City of Albuquerque Stormwater Construction Site Inspection Report

Project Name:	Campbell Coumpound				
Location:	Campbell & KaylaLn NW - 2240 Campbell Rd				
Site Contact Name & Agency	T Scott Ashcraft	ESC File No.	G13E032		
	Adam Romero	NPDES Id. No.	NMR1001ZW		
Inspection Date:	10/01/19	Start/End Time:	0940/0955hrs		
CoA Stormwater Inspector:	Timothy E. Sims				
Construction Phase:	Home Construction				
	<input checked="" type="checkbox"/> Regular	<input type="checkbox"/> Storm Event	<input type="checkbox"/> Post Storm Event >0.25"	<input type="checkbox"/> 311/Complaint	<input type="checkbox"/> Follow Up

EROSION AND SEDIMENT CONTROL PLAN

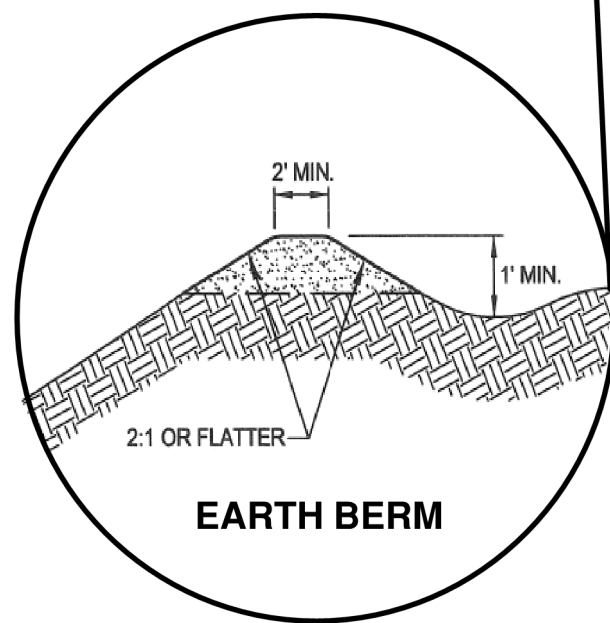
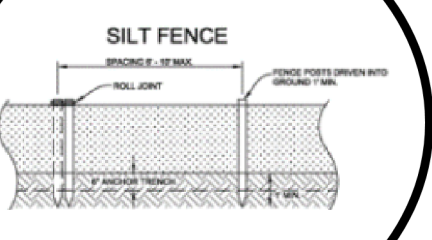
Item Number	Deficiency/ Corrective Action		
1	Please provide the latests SWPPP self-inspection report.		
2	Washout at the concrete washout facility and 2708 requires mitigation.		
3	Refuse enclosures require maintenance.		
2.1	Discharge off site? (Y/N)	No	
4	Self Inspection Reports	requested	Latest report Date: 8/20/2019
